GRANT HAYS ASSOCIATES

DATE: May 17, 2016
TO: Jennifer Bartlett – Maine State Fire Marshal Office
FROM: Mike Hays
RE: Foundation Brewery Expansion
Permit Review Comments
CC: file

Attached are the revisions to the Permit drawings which address your comments dated 4/22/16. All the revisions are Rev-Clouded with a Delta 1 designation. Please let me know if you have any additional questions.

COPYRIGHT  
REPRODUCTION OR REVISE OF THIS  
DOCUMENT WITHOUT WRITTEN  
PERMISSION FROM GRANT HAYS  
ASSOCIATES IS PROHIBITED.

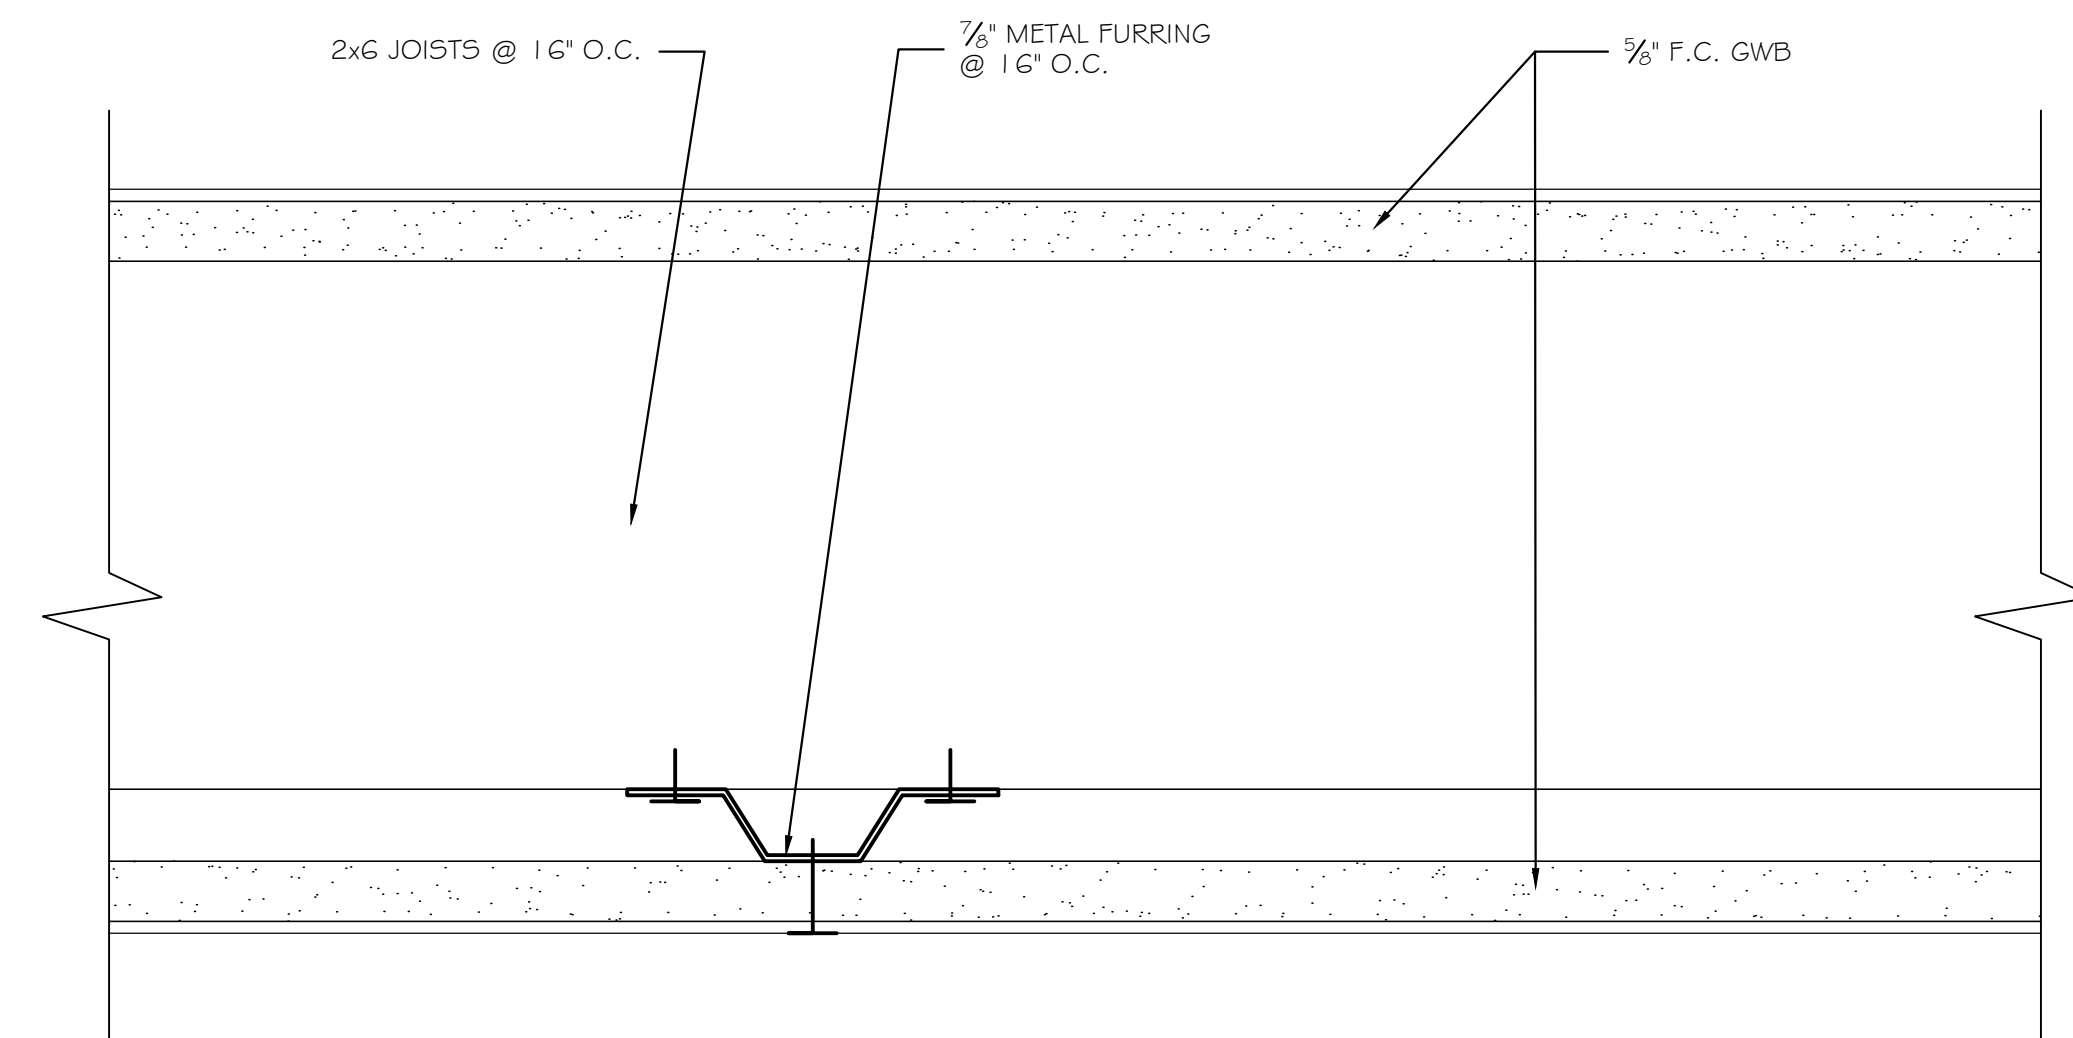
1. Added section thru New One-Hour Rated Boiler Room enclosure at the existing boiler in Production 105.
2. Added section thru New ADA Toilets depicting extension of existing mezzanine floor structure above over new Toilets for bearing condition.
